TfNSW Reference: SYD25/00508/02
Department Reference: SSD-77260958

**RESPONSE TO SUBMISSIONS FOR HOTEL, COMMERCIAL OFFICE PREMISES AND RESIDENTIAL APARTMENTS
2-4 BURLEIGH STREET AND 20-24 RAILWAY PARADE, BURWOOD**

TAB A - Advisory comments and TfNSW recommendations

GROUND FLOOR PLAN

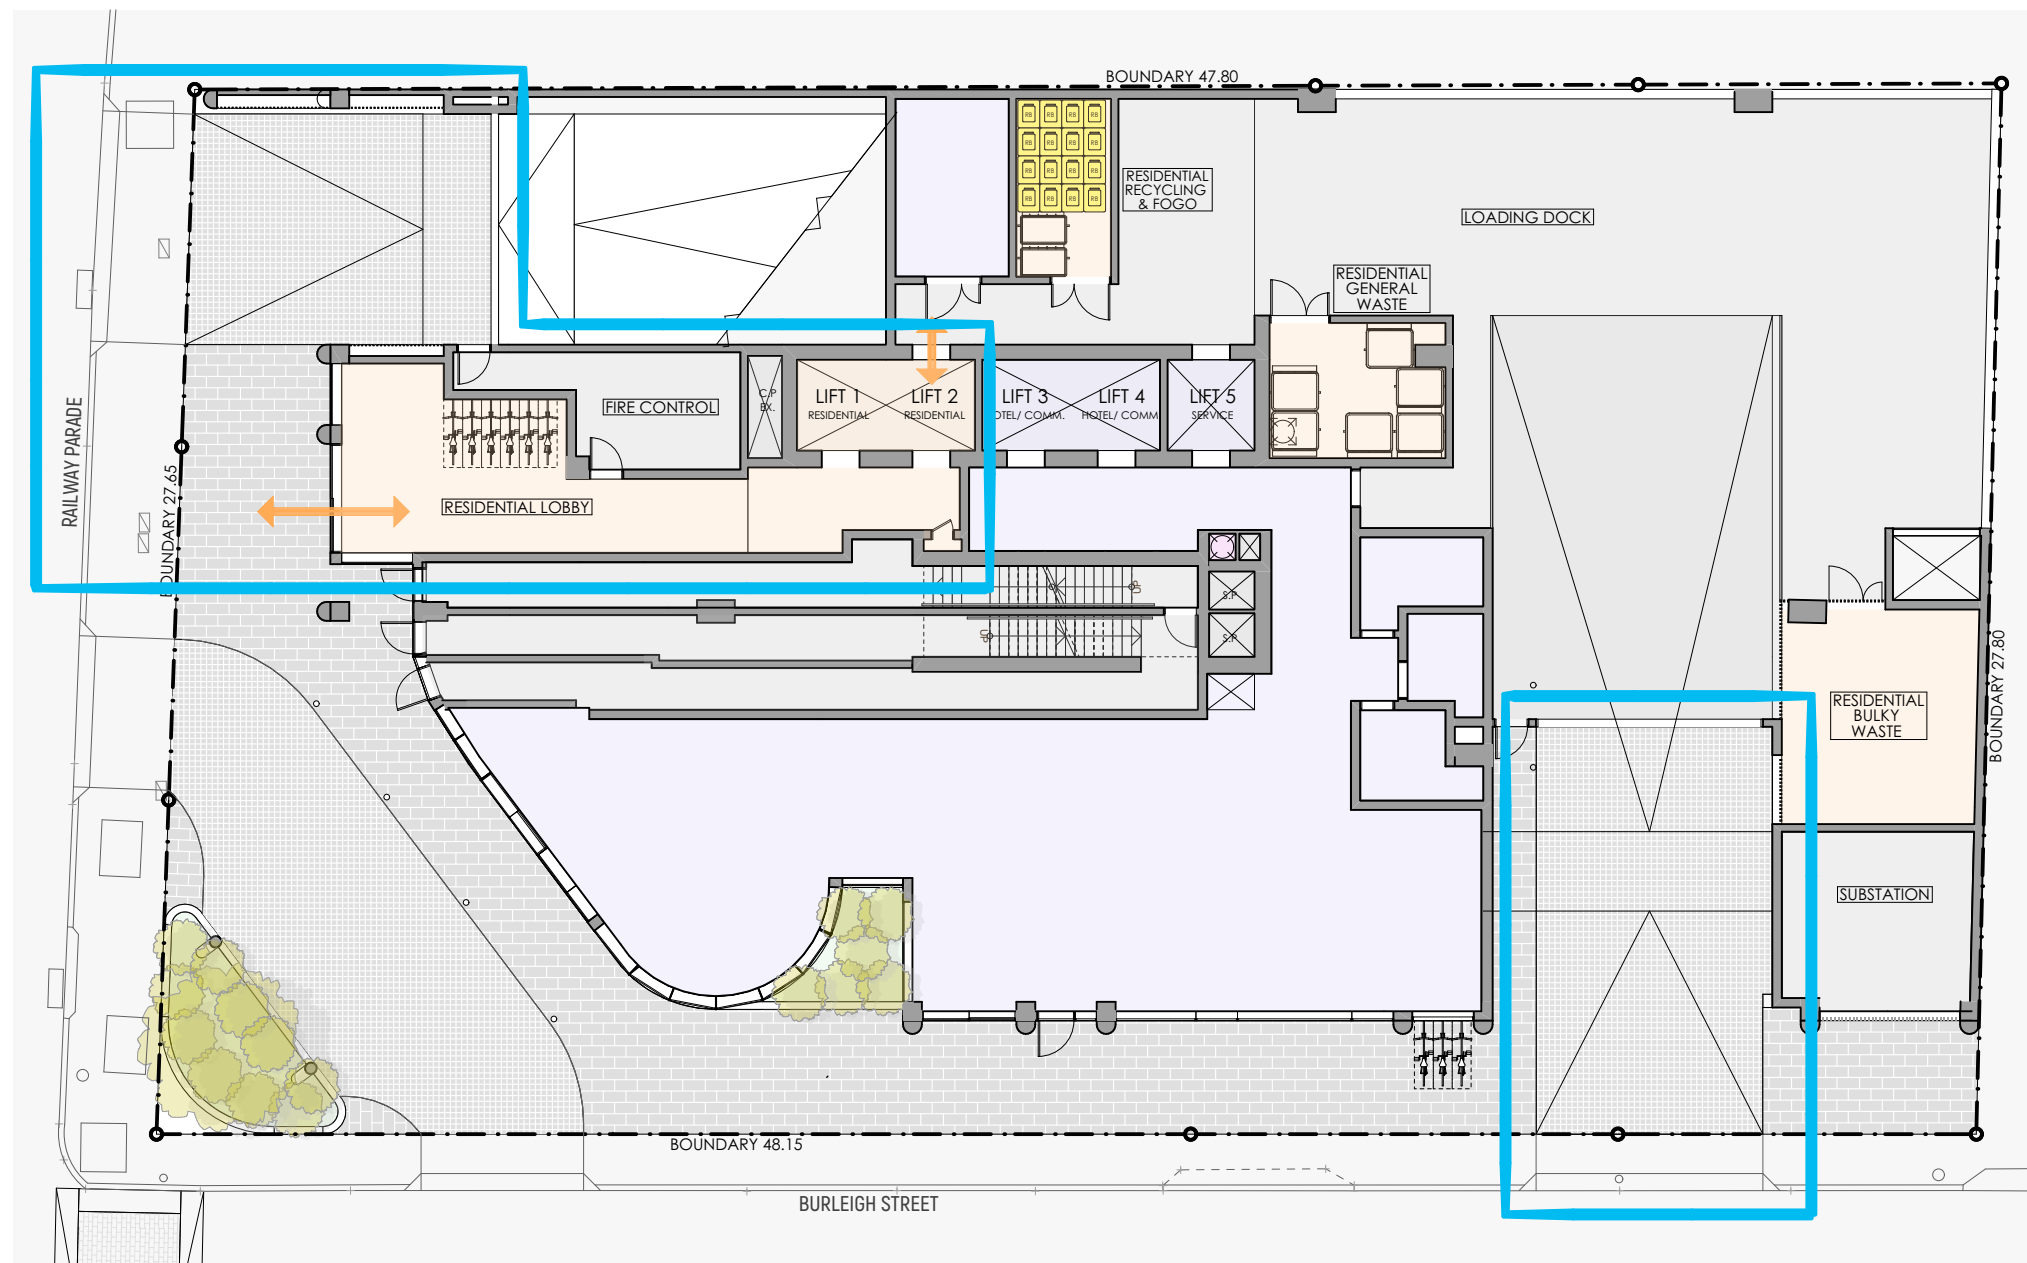
- The layout of the Porte-cochere is within the prohibited location of access driveways reference to AS 2800.1:2004 Section 3.2.4 Figure 3.1.
- Clear sight lines are to be provided at the property line to ensure adequate visibility between vehicles using the Porte-cochere. Considering the high pedestrian activity at this location, clear sight lines are required.

- TfNSW advises that the agency has reported existing undesirable weaving movements are frequently observed by road users from lane 2 to lane 1 near the proposed porte-cochere location to avoid downstream buses waiting to turn right. Any queuing arising out of the proposed porte-cochere could exacerbate existing issues and the design should consider the existing road environment and future users of the development.

- Basement exit/entry driveway at Railway Parade is not perpendicular to the vehicle crossover where entry requires a partial U-turn from Railway Parade to avoid conflicts with exiting vehicles. Furthermore, the exit angle of the driveway prior to the property boundary also minimises the visibility of pedestrians along Railway Parade, which is unacceptable. Further information on pedestrian and vehicular management in Austroads Guide to Traffic Management Part 5: Road Management 2019 and Australian Standards should be referenced.

- A minimum of 3 car spaces (18 metres) is required to service the 138 proposed parking spaces Ref AS 2800.1:2004. The proposal is in the order of 8 metres from the motorised gate to the property boundary which not comply and could result in queuing onto the classified roadway, impacting transport operations.

- An adjoining breakdown lane strip 2.0 wide provided on one side of a single queuing lane. Ref AS 2800.1:2004 Section 3.4 Table 3.3 has not been provided.

The submitted plans do not demonstrate compliance with AS: 2800:2004 and other relevant technical guidelines. Existing transport network operations and high pedestrian activity at this location require this to be addressed by the Applicant.

The access driveway for the Porte cochere needs to comply with AS 2890.1:1994 and have clear sight lines to in accordance with Figure 3.1 Section 3.2.4 AS 2890,1:2004.

TfNSW will require the Applicant to address these prior to any concurrence under section 138 of the *Roads Act, 1993* being provided. Due to the design changes to the development and to avoid further modifications, TfNSW recommends that this occurs prior to any determination issued by the DPHI.
